From: Sarah Burrow <Sarah.Burrow@arun.gov.uk>
Sent: 28 October 2020 11:48
To: Planning.Responses <Planning.Responses@arun.gov.uk>
Cc: Zac Denton <Zac.Denton@arun.gov.uk>
Subject: RE: Planning Consultation on: M/71/20/HH

Engineers Comments Regarding Surface Water Drainage

Application No: M/71/20/HH
Registered: 22nd September 2020
Site Address: 18 Sea Way Elmer Middleton-On-Sea PO22 6JY
Grid Reference: 498972 100285
Description of Works: Construction of first floor dormer to provide enlarged bathroom and wardrobe/storage, construction of detached garage

DRAWING TITLE
**PROPOSED DETACHED GARAGE
FLOOR PLAN AND ELEVATIONS**

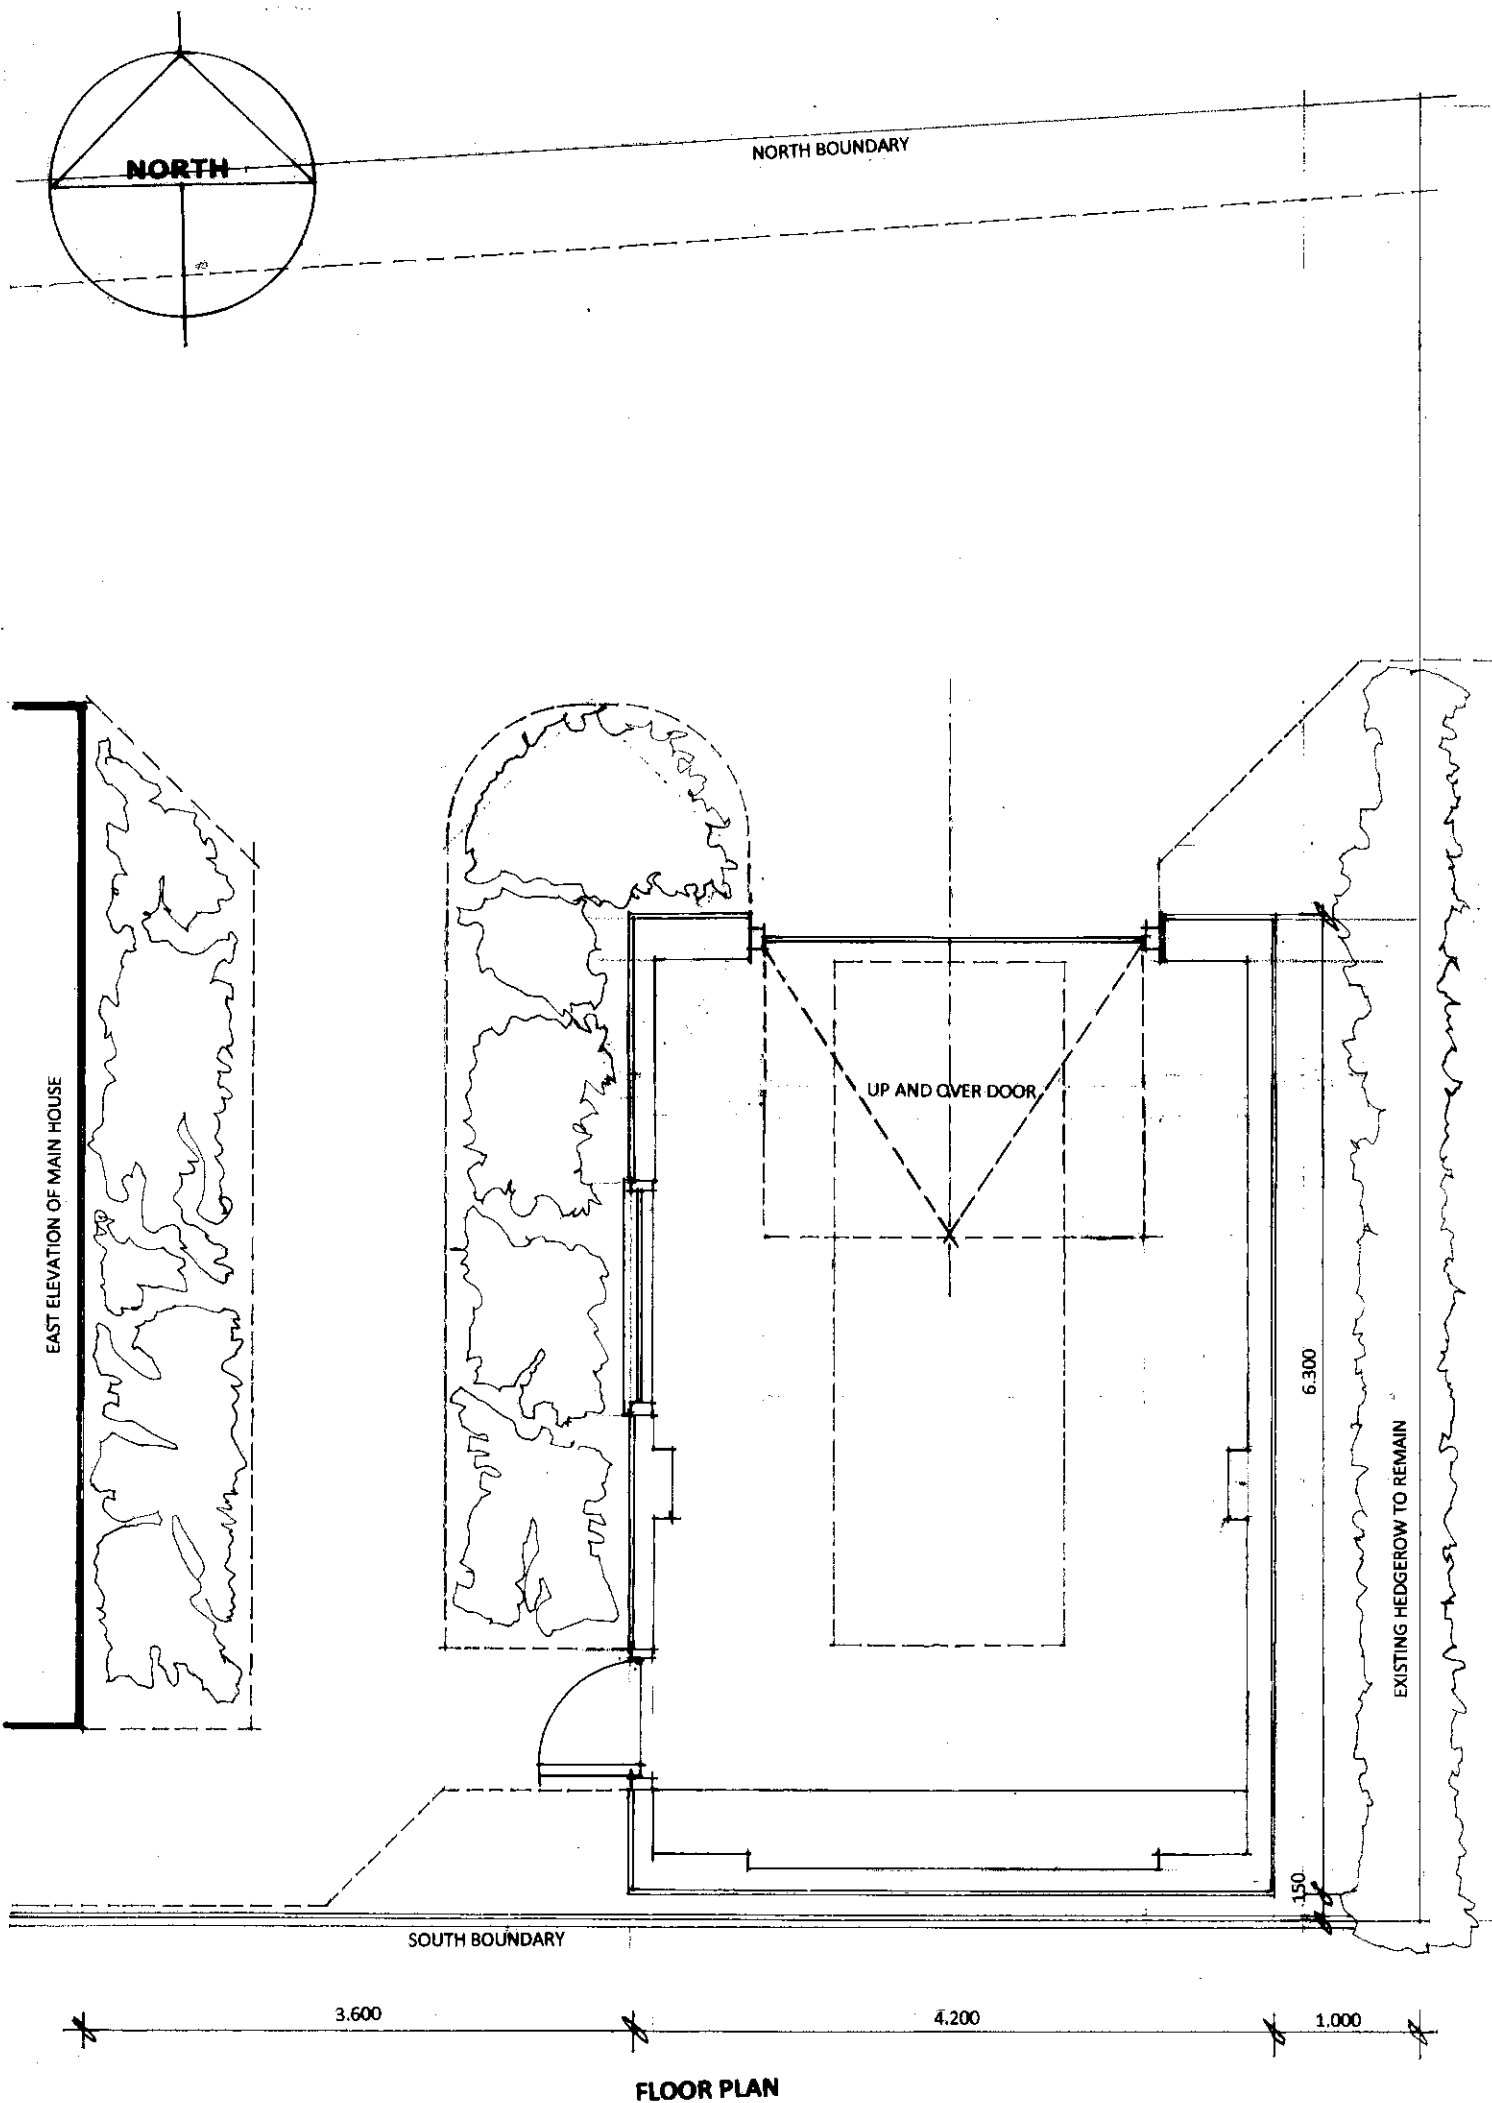
All comments relate to the proposed garage.

The site lies in Flood Zone 3, is adjacent to an Internal Drainage Board (IDB) watercourse, is in proximity of historic reported flooding and within the Lidsey Treatment Catchment where surface water is carefully managed to avoid additional flows to the foul sewer.

Infiltration must be fully investigated.

It should be noted that if groundwater is close to ground level or infiltration is proven to not be possible, then it may be necessary to obtain consent to discharge surface water at a restricted rate to the IDB watercourse.

"Development shall not commence, other than works of site survey and investigation, until full details of the proposed surface water drainage scheme have been submitted to and approved in writing by the Local Planning Authority. The design should follow the hierarchy of preference for different types of surface water drainage disposal

systems as set out in Approved Document H of the Building Regulations, and the recommendations of the SuDS Manual produced by CIRIA. Winter groundwater monitoring to establish highest annual ground water levels and winter Percolation testing to BRE 365, or similar approved, will be required to support the design of any Infiltration drainage. No building / No part of the extended building shall be occupied until the complete surface water drainage system serving the property has been implemented in accordance with the agreed details and the details so agreed shall be maintained in good working order in perpetuity."
